Whitestone Solar Farm

Planning Inspectorate Application ref. EN0110020

Appendix A – Applicant's response to Section 51 and Section 55

APPLICATION NUMBER: EN0110020

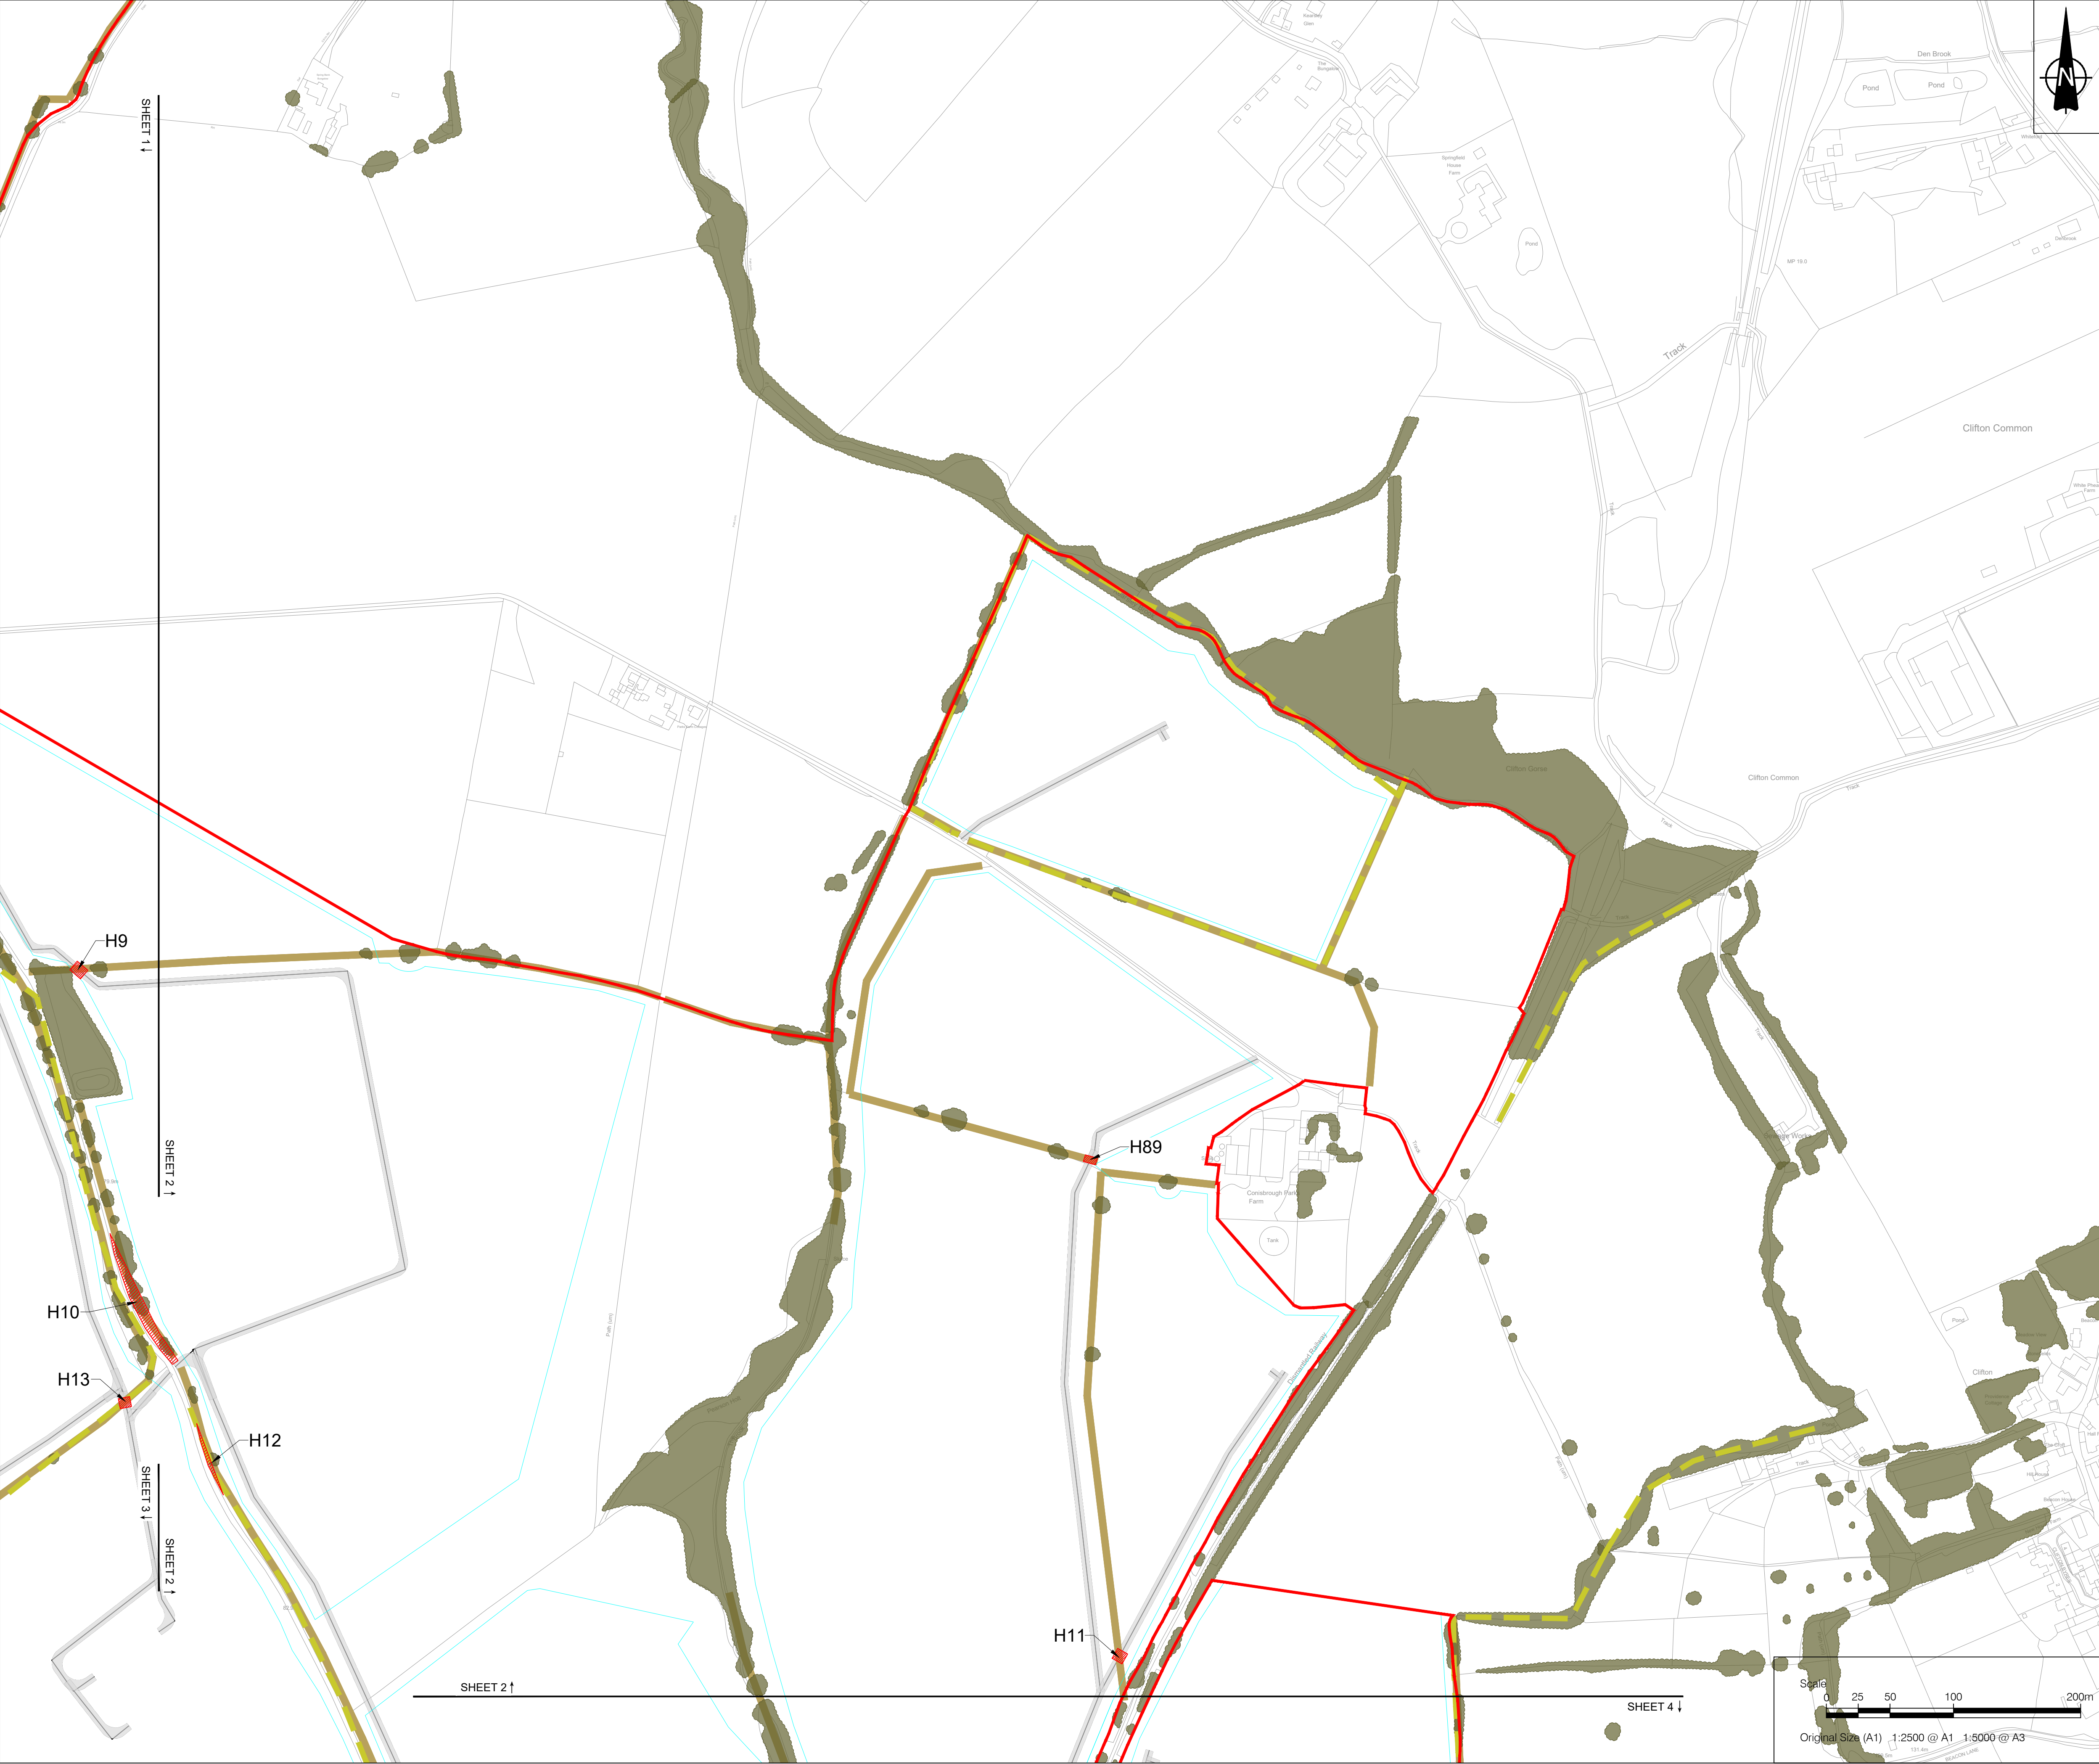
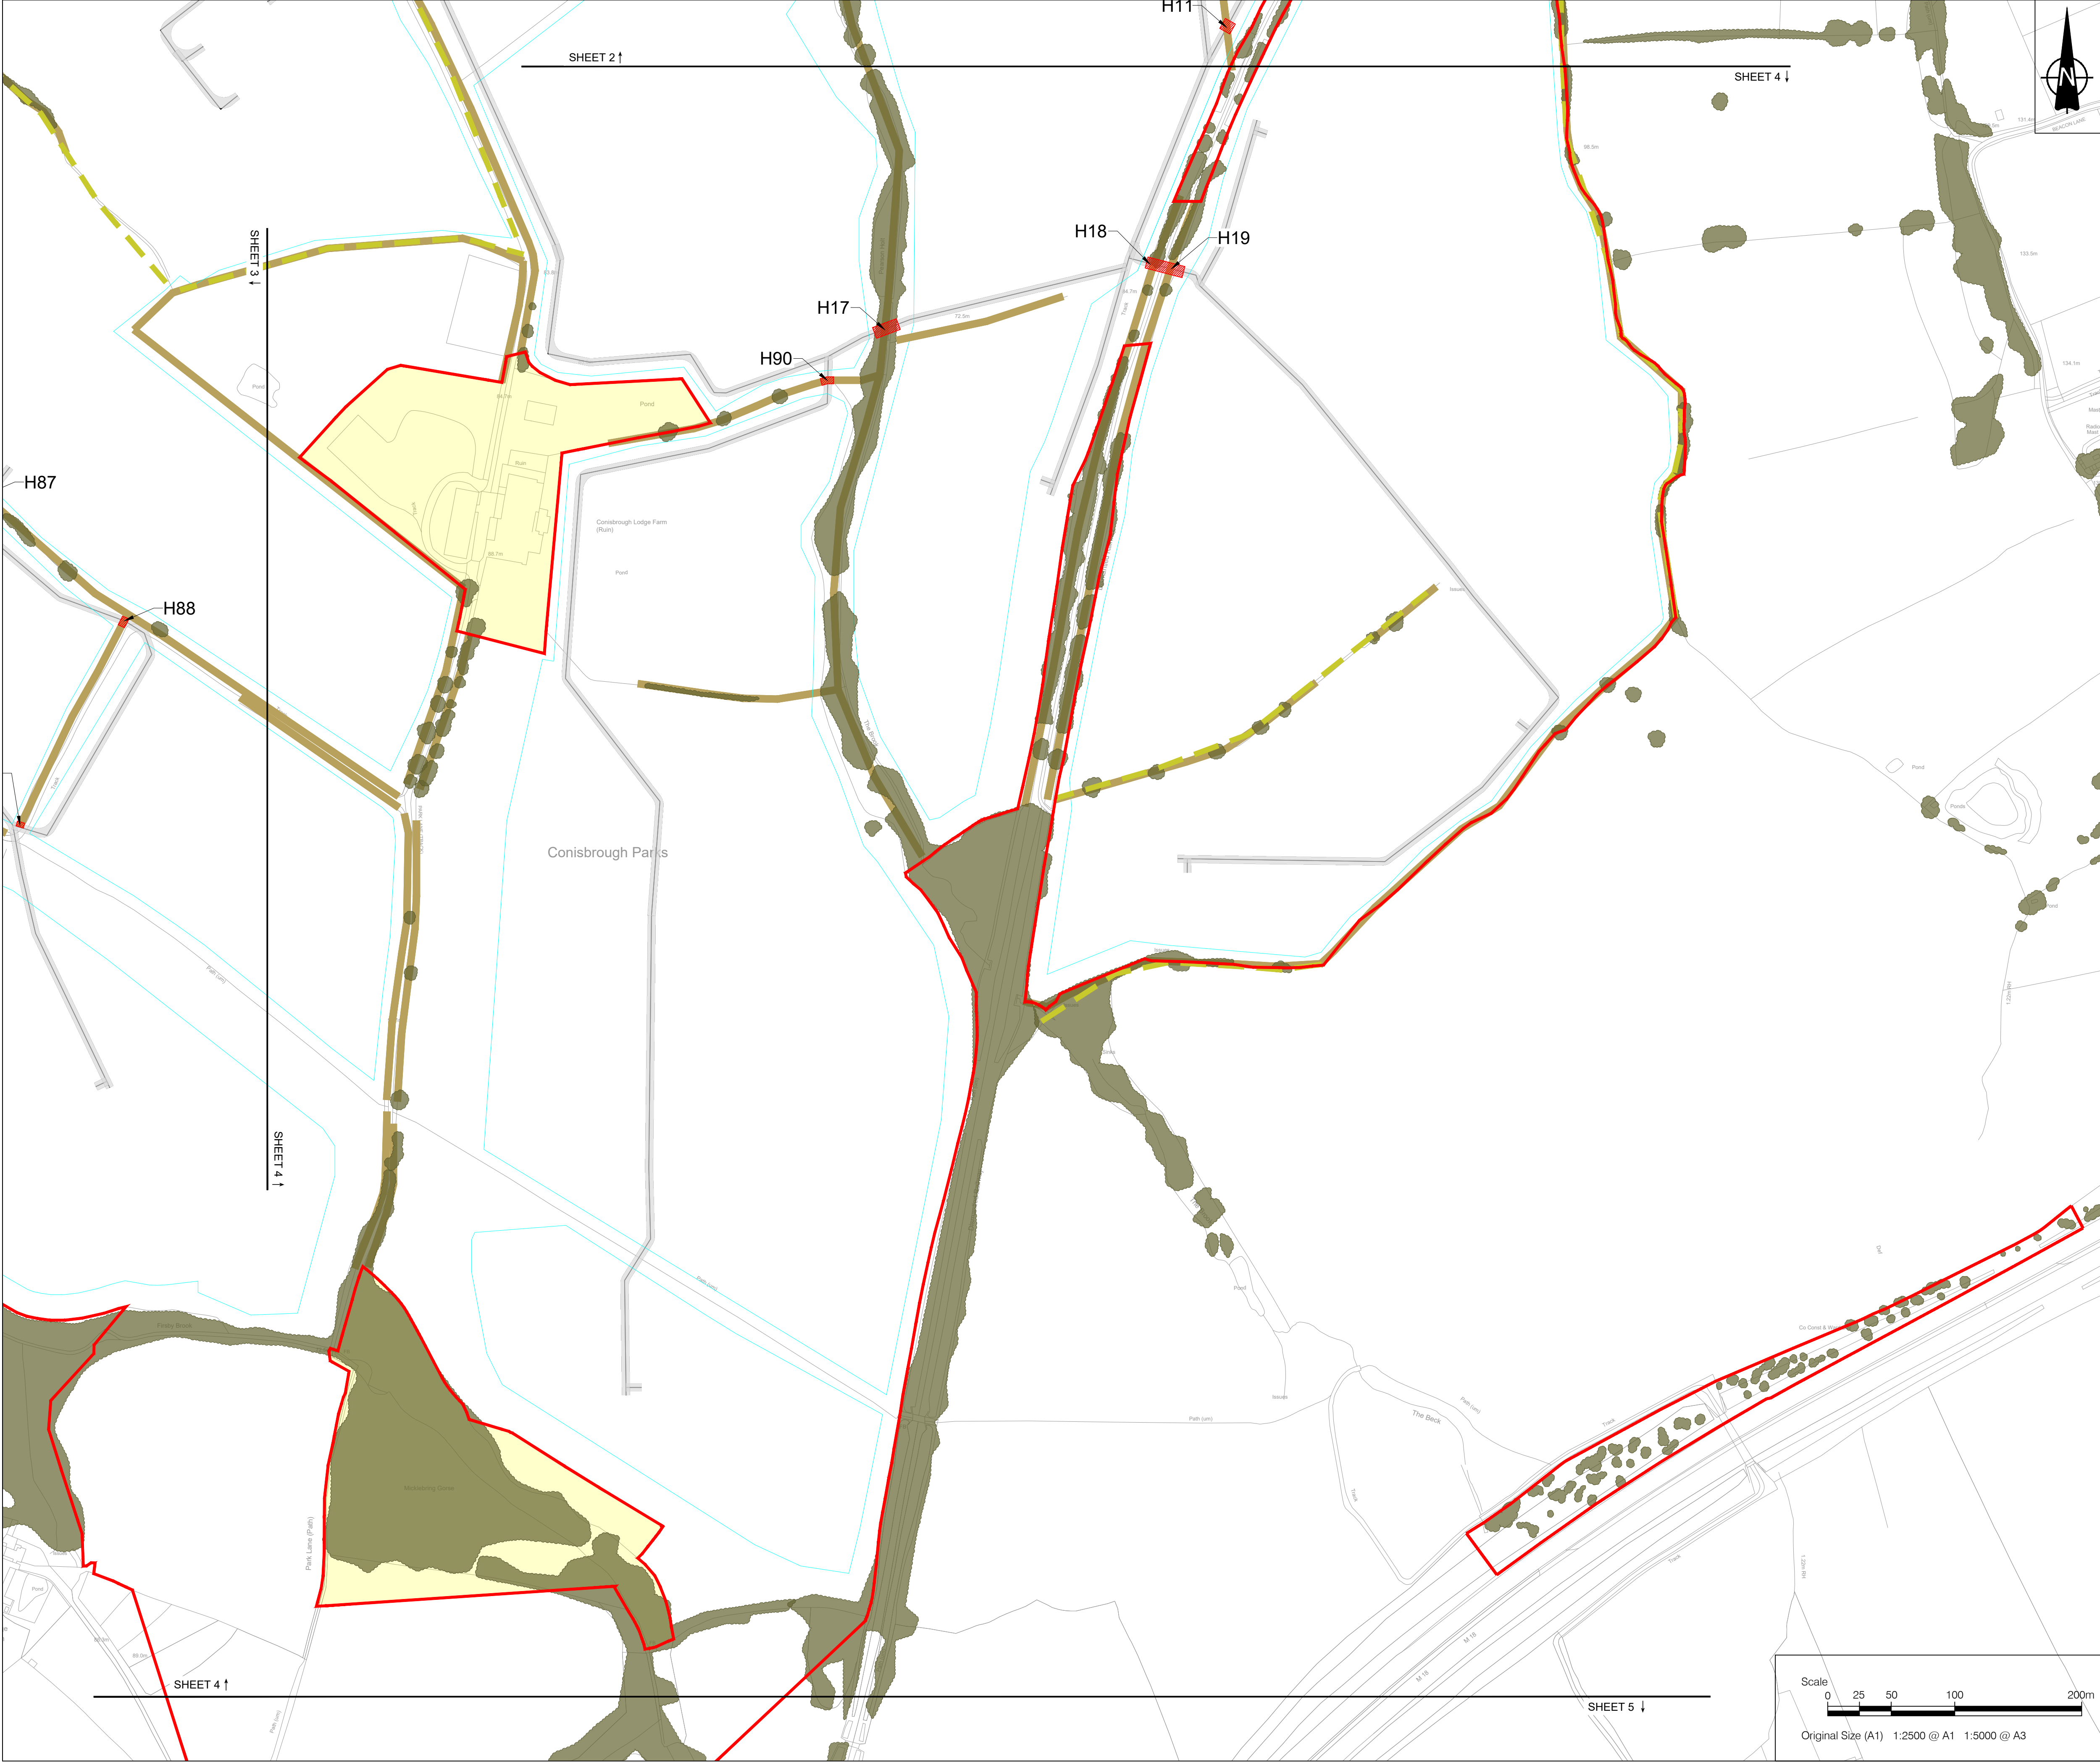
of Changes to the draft Development Consent Order [EN0110020/APP/8.1].	Schedule of Changes to the draft Development Consent Order [EN0110020/APP/8.1].
	Outline Public Rights of Way Management Plan (Doc 5.12) references referred to need to be checked throughout the document.	The Applicant notes this request, but the Outline Public Rights of Way Management Plan is document ref. 5.14 (APP-047). The Applicant has reviewed this document in accordance with the comment and noted no updates were required. However, while reviewing the Applicant also reviewed the Outline Construction Traffic Management Plan (document ref. 5.12) and updates were subsequently required to ensure all references were correct.	Updated Outline Construction Traffic Management Plan [EN0110020/APP/5.12.1] (clean and tracked).
	Location Plan (Doc 2.1) and Vegetation Removal Plans (Doc 2.9) it would be useful for these plans to show land excluded from order limits.	The Location Plan and Vegetation Removal Plans have been updated to show land excluded from the Order Limits in a yellow colour.	Updated Location Plans [EN0110020/APP/2.1.1] (clean and tracked). Updated Vegetation Removal Plans [EN0110020/APP/2.9.1] (clean and tracked).
